March 2, 2005

RE:Permit #98-1334 / 45 Gleckler Rd. (141 F041)

SIDE ELEVATION
SCALE 1/4" = 1'-0"

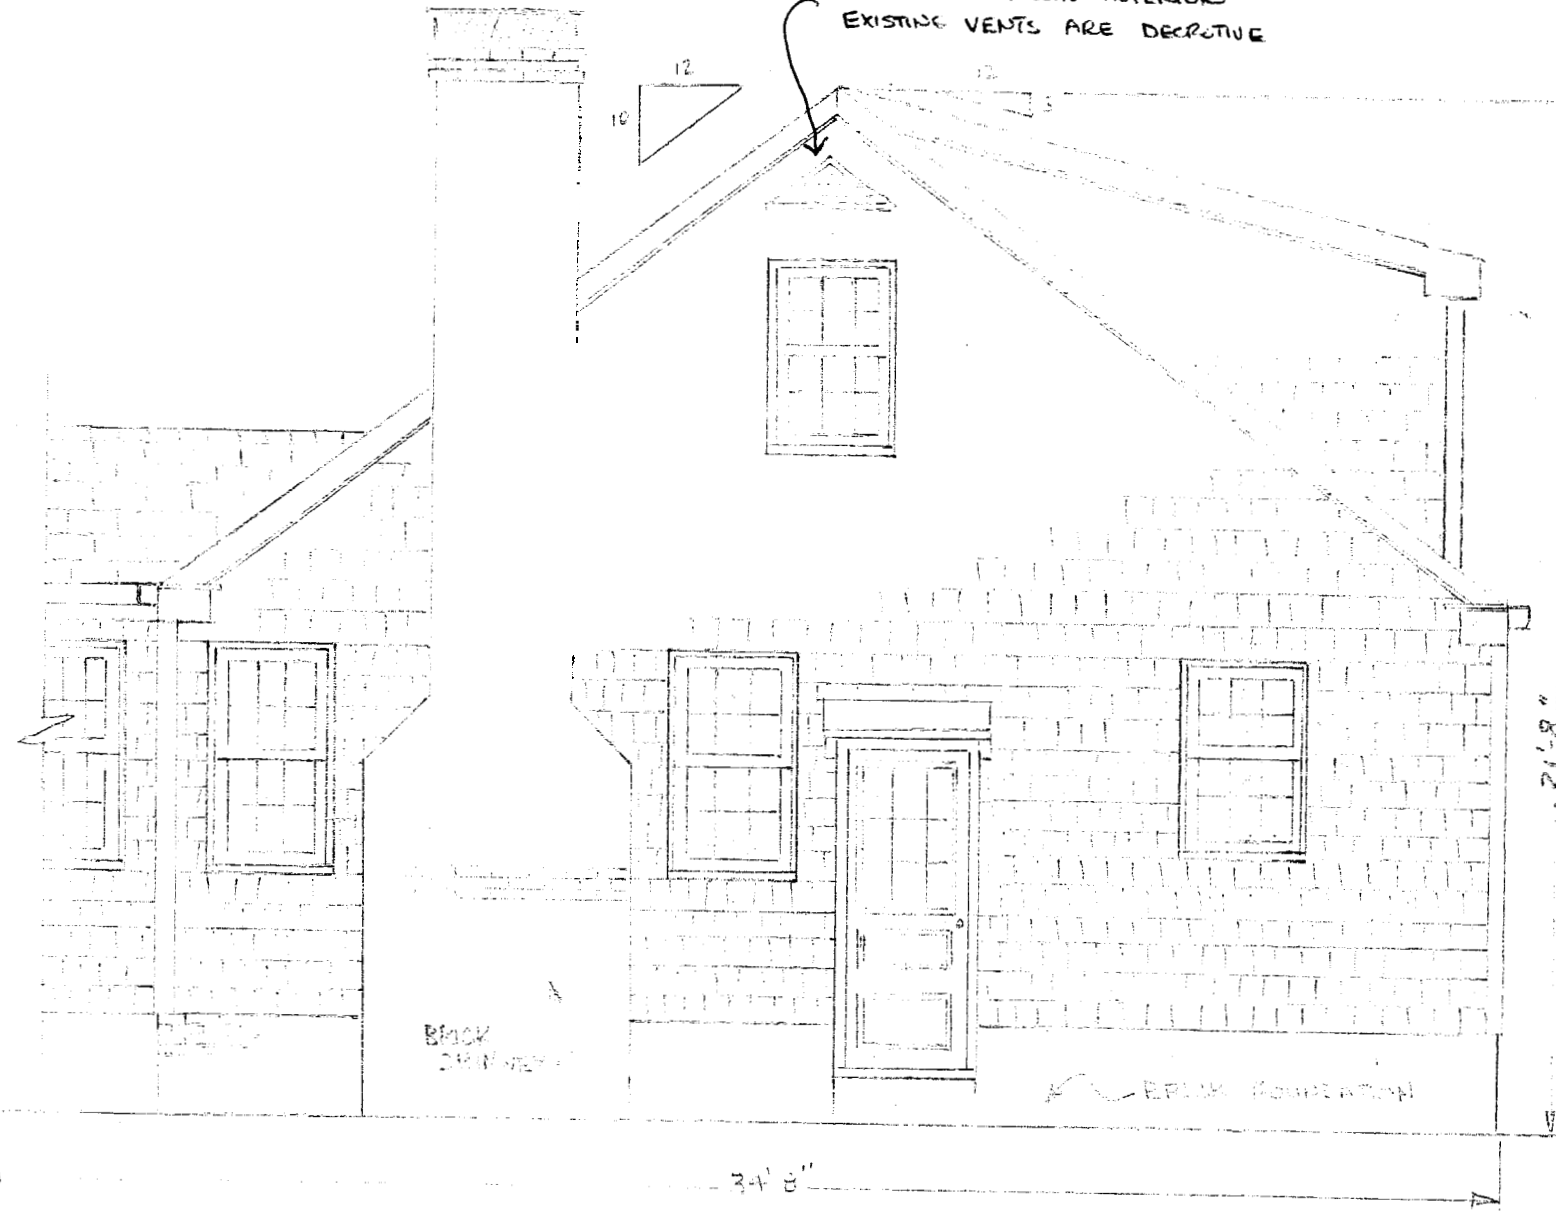
- 4) The former gable vents must be removed to provide a weather tight wall. This is a violation of Section 1403.3 of the 1996 BOCA Code.
- 5) The recessed lighting appears to be installed in violation of its UL listed purpose. This is a violation of the 1996 National Electrical Code.

SOFFIT DETAIL
SCALE 1/2" = 1'-0"

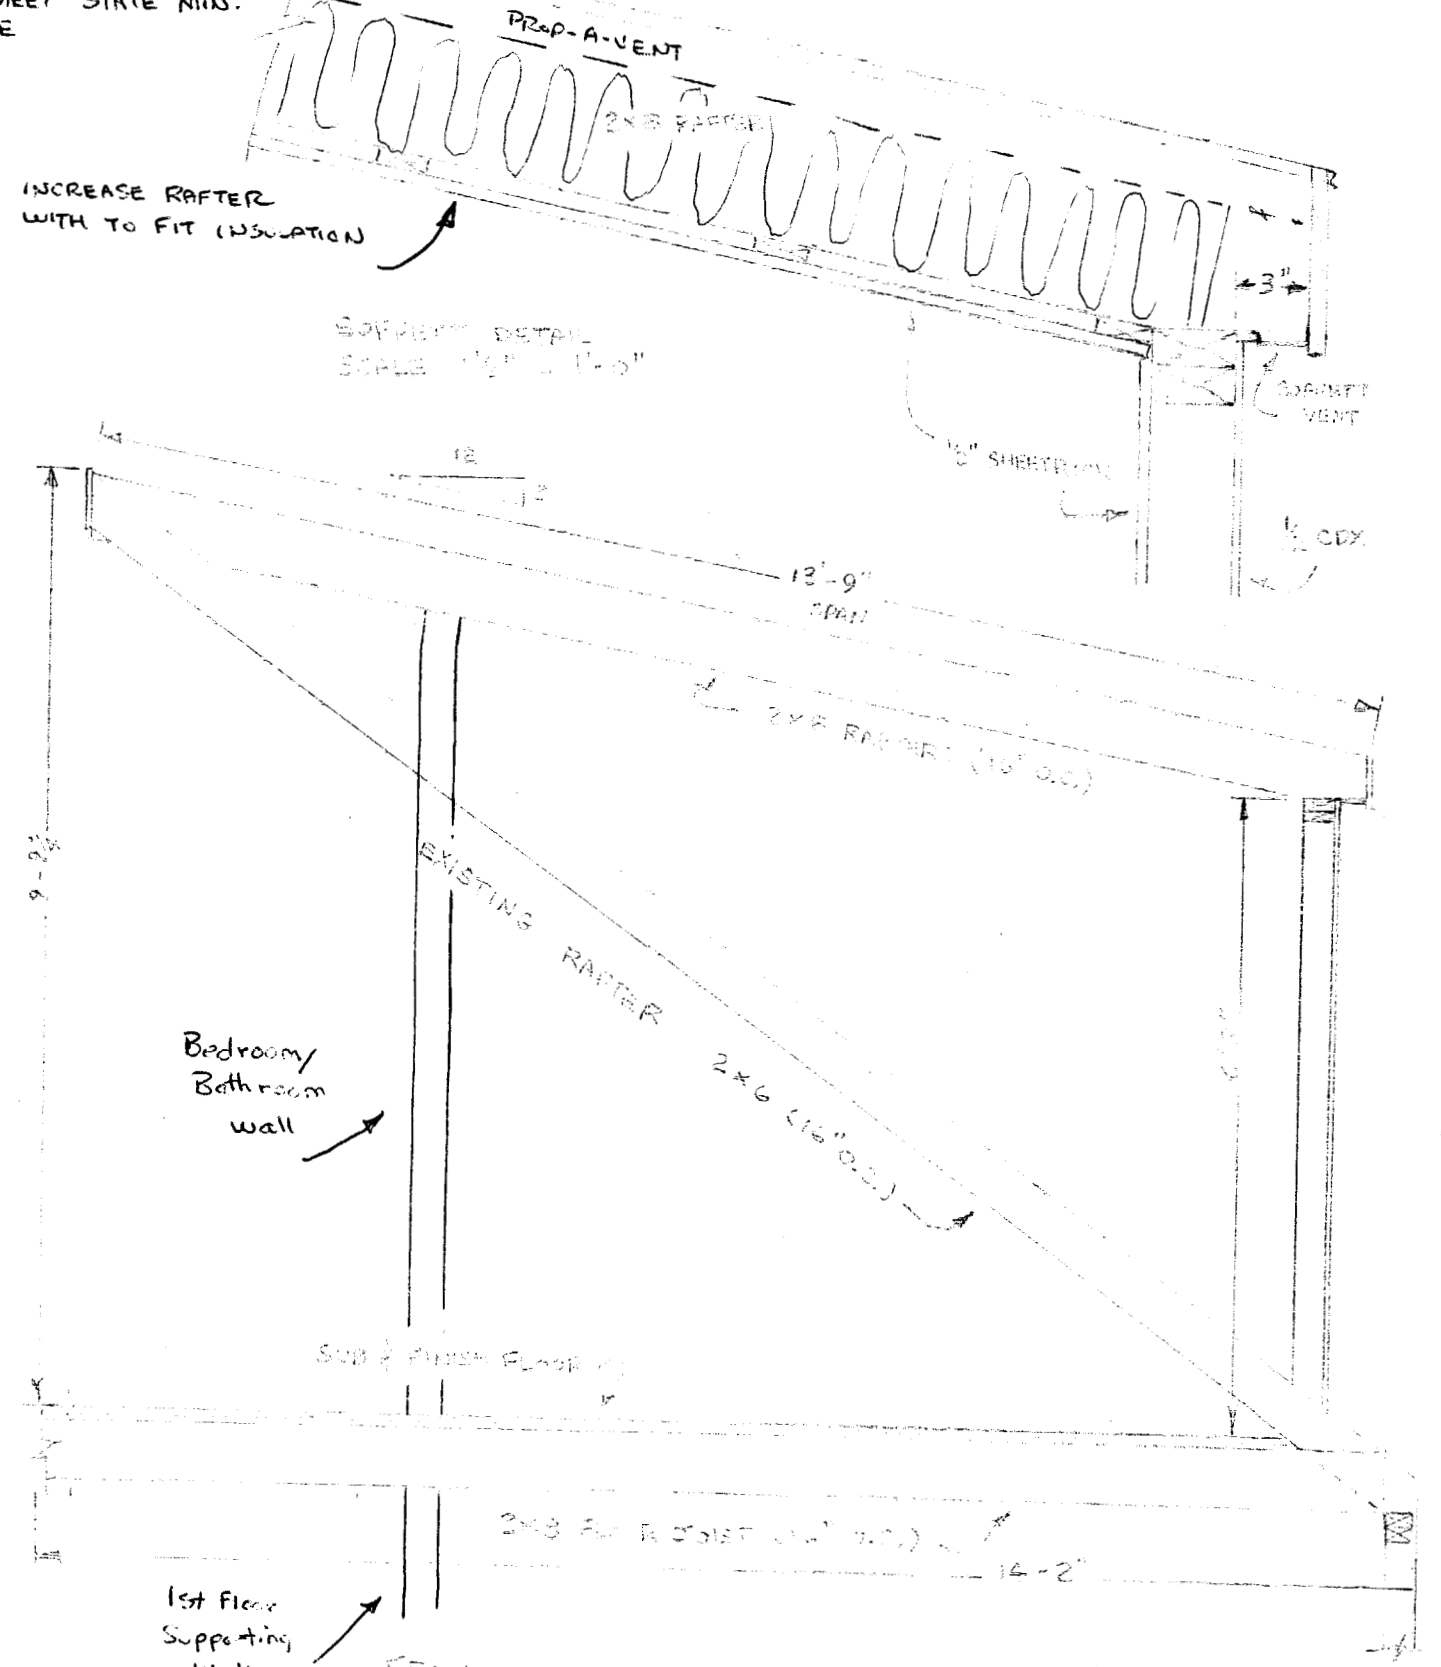
- 3) The enclosed rafter spaces do not allow cross ventilation as the design of the ridge vent is improper, a violation of section 1210.1 of the 1996 BOCA Code.

FRAME DETAIL
SCALE 1/2" = 1'-0"

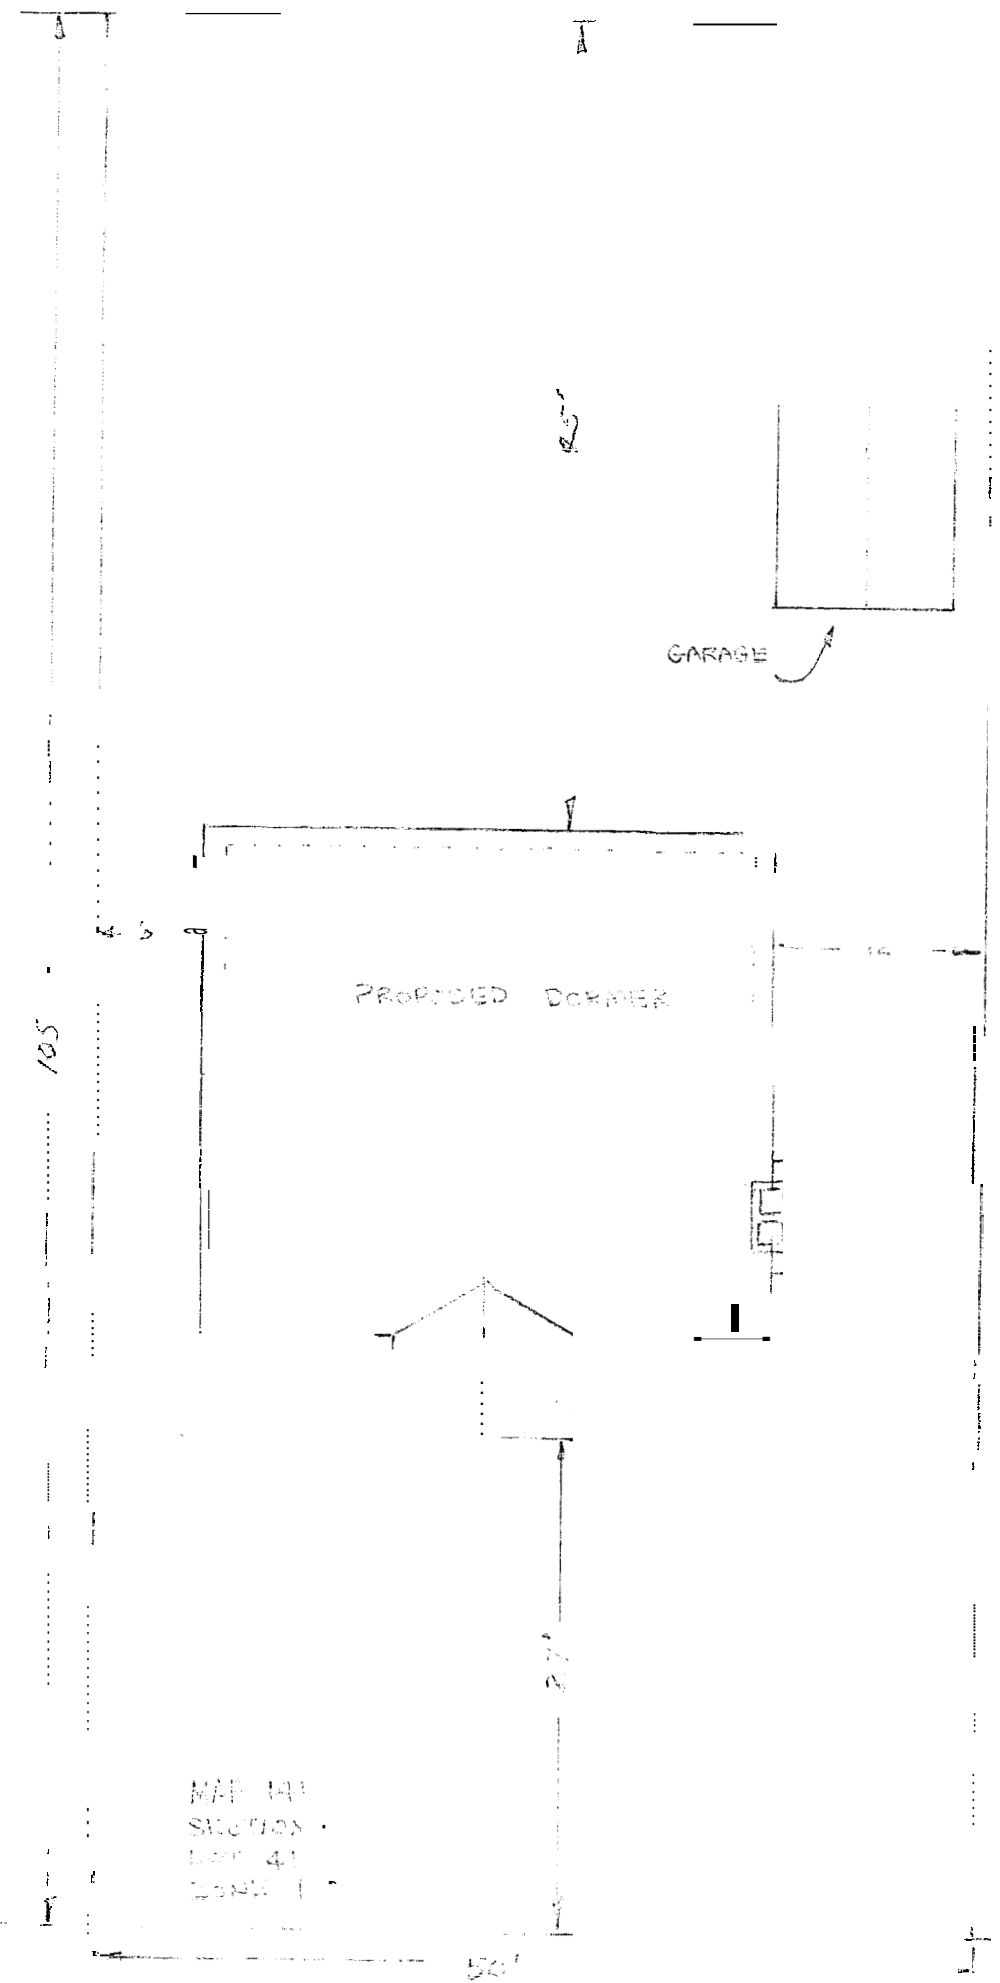
- 1) The Roof Rafter Span is 14 feet 7 inches. The Lumber used is 2" x 8" spaced 16 inches on center. Section 2305.15 of the 1996 BOCA Code (the code in effect at the time of construction) requires that design stresses for rafters comply with AFPA NDS (1991). The maximum allowable span for the previously described installation is 12 feet. This is a violation of Section 2305.15

- 2) The ridge installed is a single member. Because the pitch of the roof is less than 3:12, it is required that this member be an appropriately designed header or beam. The absence of this is a violation of Section 802.3 and 802.4 of the CABO one and two family dwelling code. (Adopted by reference in 310.6 of the 1996 BOCA Code)
